Norwich to Tilbury

**Document: 9.1 Notification of proposed change to DCO application -
Change Request 1 (Bulphan)**

Application by National Grid Electricity Transmission (the Applicant) for an Order Granting Development Consent for the Norwich to Tilbury Project (Planning Inspectorate Reference EN020027)

Bulphan: Change to Third Party Access and Works (Change Request 1)

Application Document 9.5

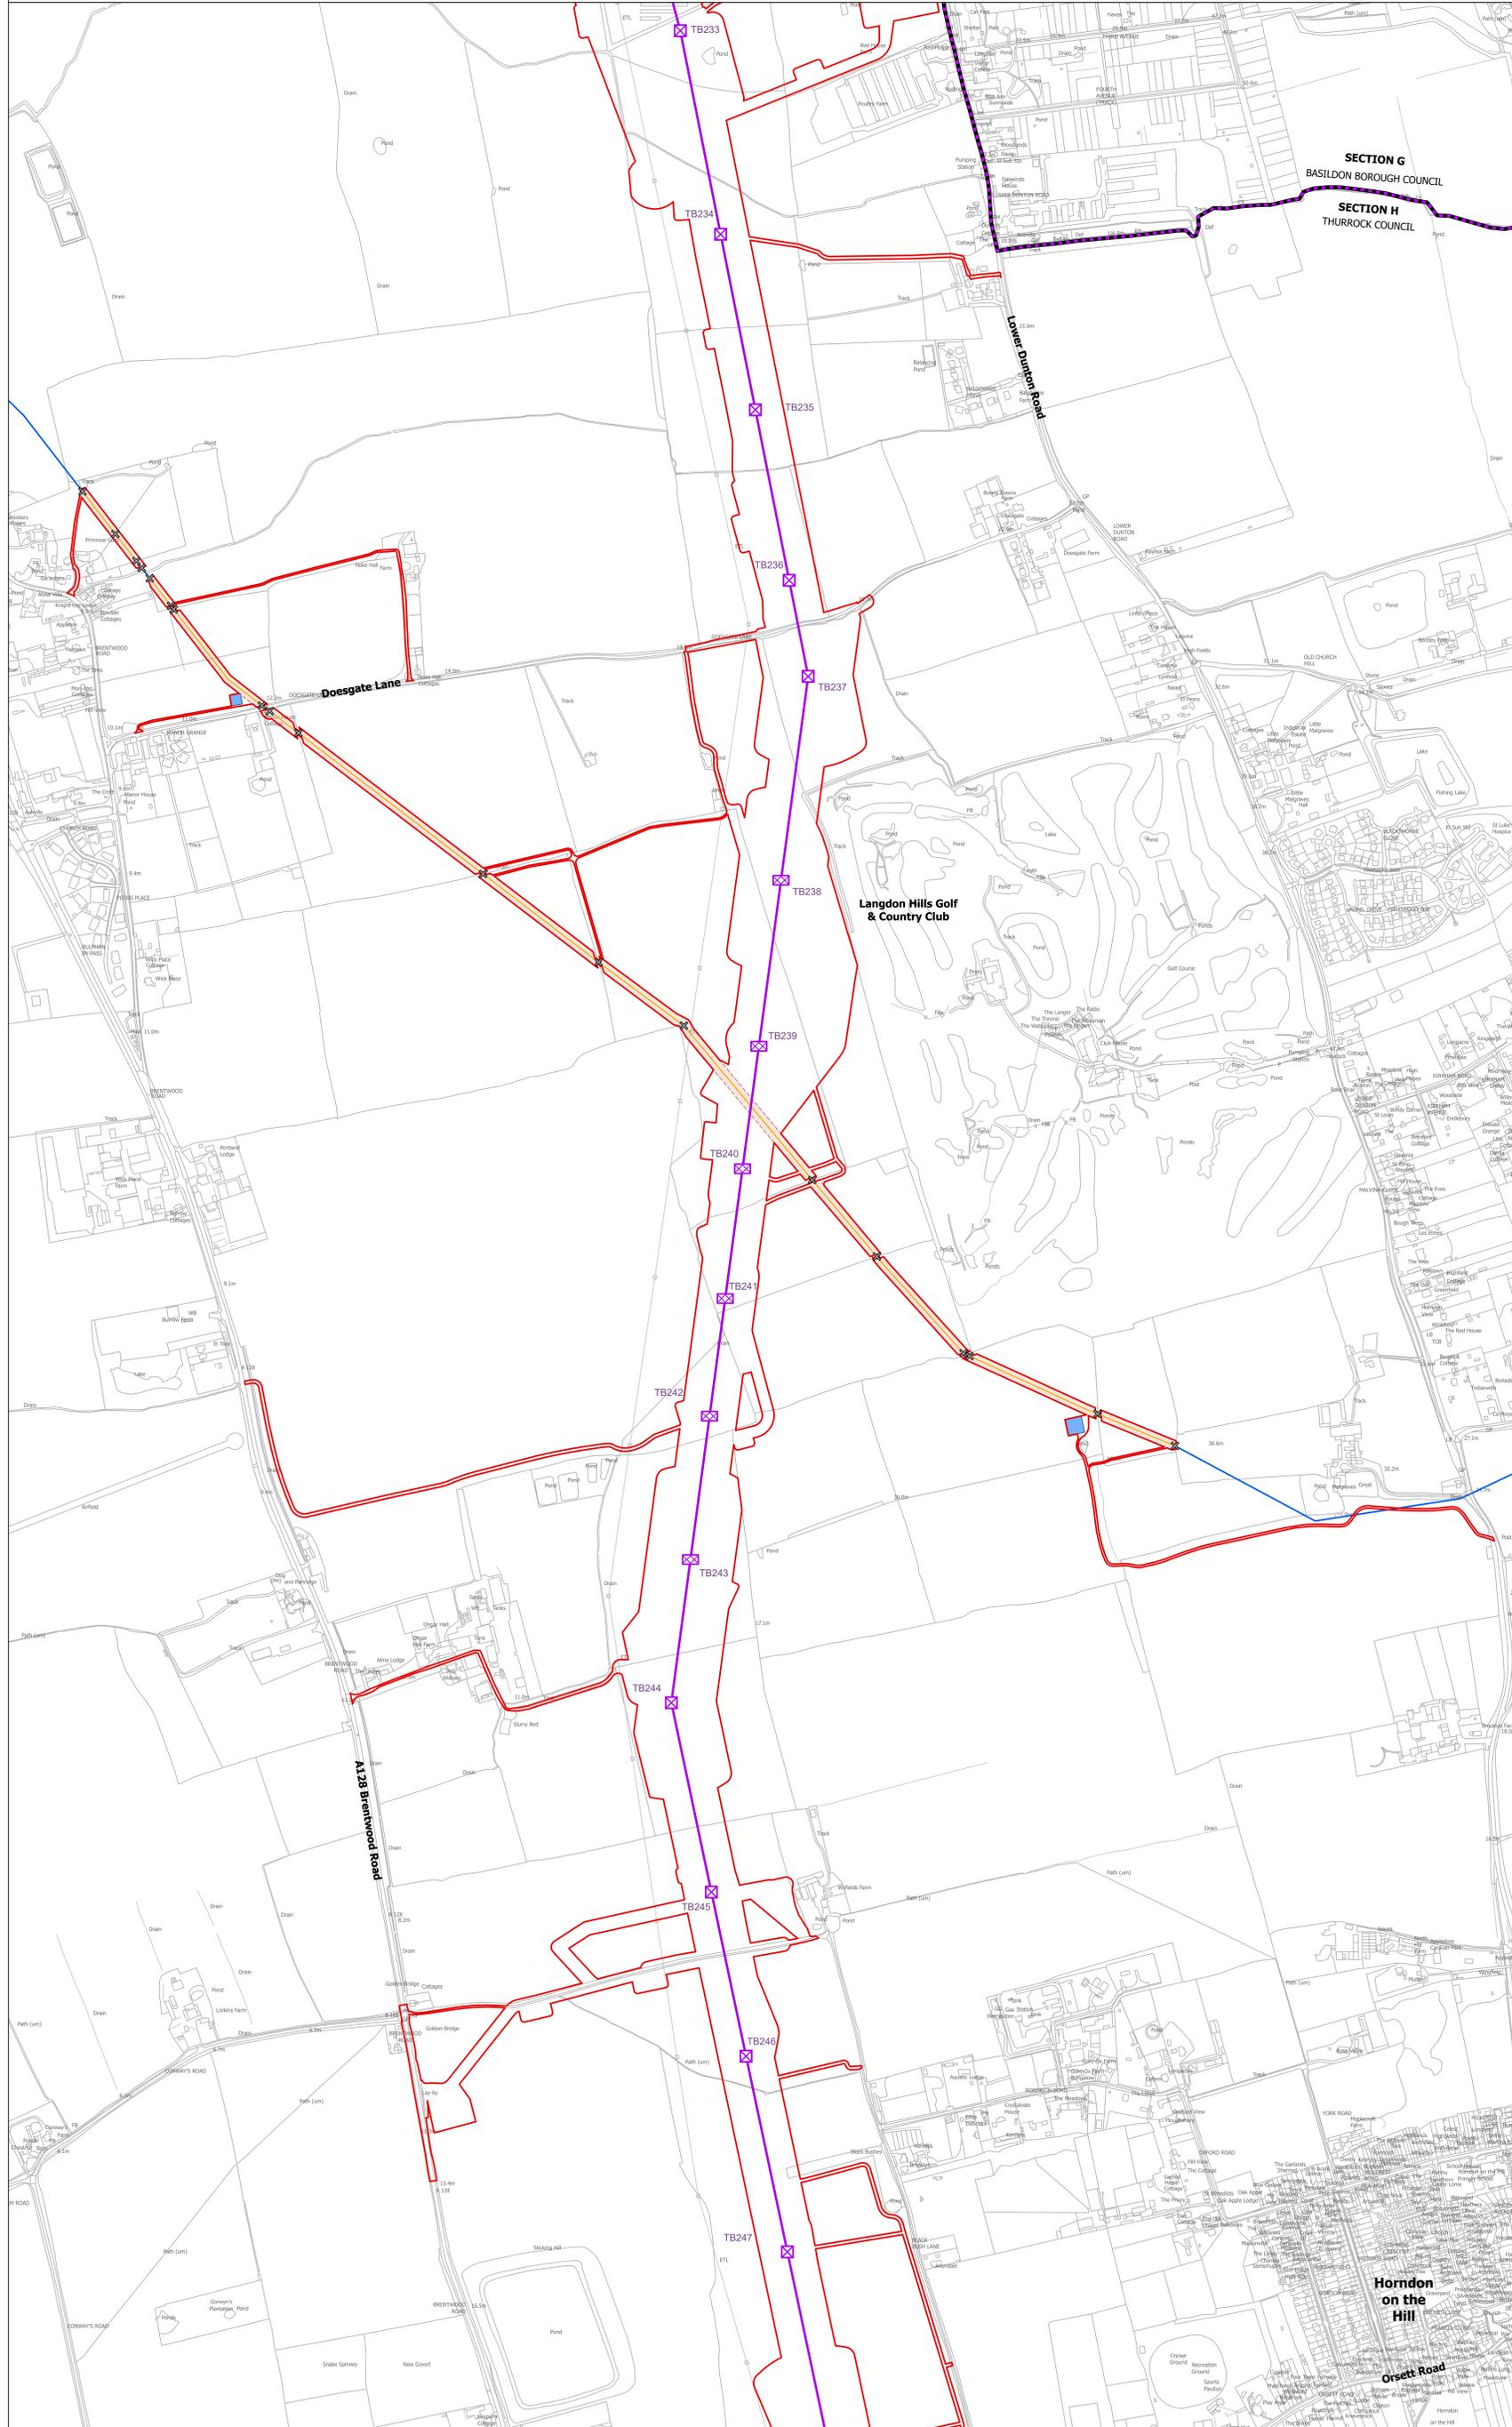
Change request number	Name of proposed change and description
1	Bulphan: Changes to third party access and works (Section H): an increase in the Order Limits to facilitate works required for the protection of the existing Thames to Buncefield Multifuel Pipeline, west of Langdon Hills Golf Club. This proposed change responds to feedback concerning accelerated corrosion on existing buried metallic services received from the British Pipeline Agency Ltd (BPA) who act as the agent for the owner, United Kingdom Oil Pipelines Limited (UKOP).

- 2.1.5 The proposed alignment for the Project (between Pylon TB239 and TB240) (see Section H of **Works Plans (APP-024)**) will cross the Thames to Buncefield Multifuel Pipeline to the west of Langdon Hills Golf Club. The pipeline, which forms part of the national fuel infrastructure network, is operated by the British Pipeline Agency Ltd (BPA) who act as agent for the owner United Kingdom Oil Pipelines Limited (UKOP).

- 2.1.6 As part of ongoing technical and survey work to inform detailed design, the Applicant has undertaken pipeline studies. The work identified the need for mitigation works to be carried out in respect of the existing Thames to Buncefield Multifuel Pipeline. The proposed measures are likely to involve the installation of zinc earthing strips parallel to, and along, an approximately 2.7km length of the existing pipeline, along with the installation of surface mounted monitoring equipment units. Temporary working and laydown areas will also be required.

- 2.1.10 The Order Limits are to be increased as a consequence of the proposed change, with powers of compulsory acquisition and temporary possession to be sought by the Applicant over the additional land intended to be brought within the Order limits. Accordingly, the CA Regulations are engaged.

2.1.12 The proposed change to the Order Limits is shown on the figures in **Appendix A**.
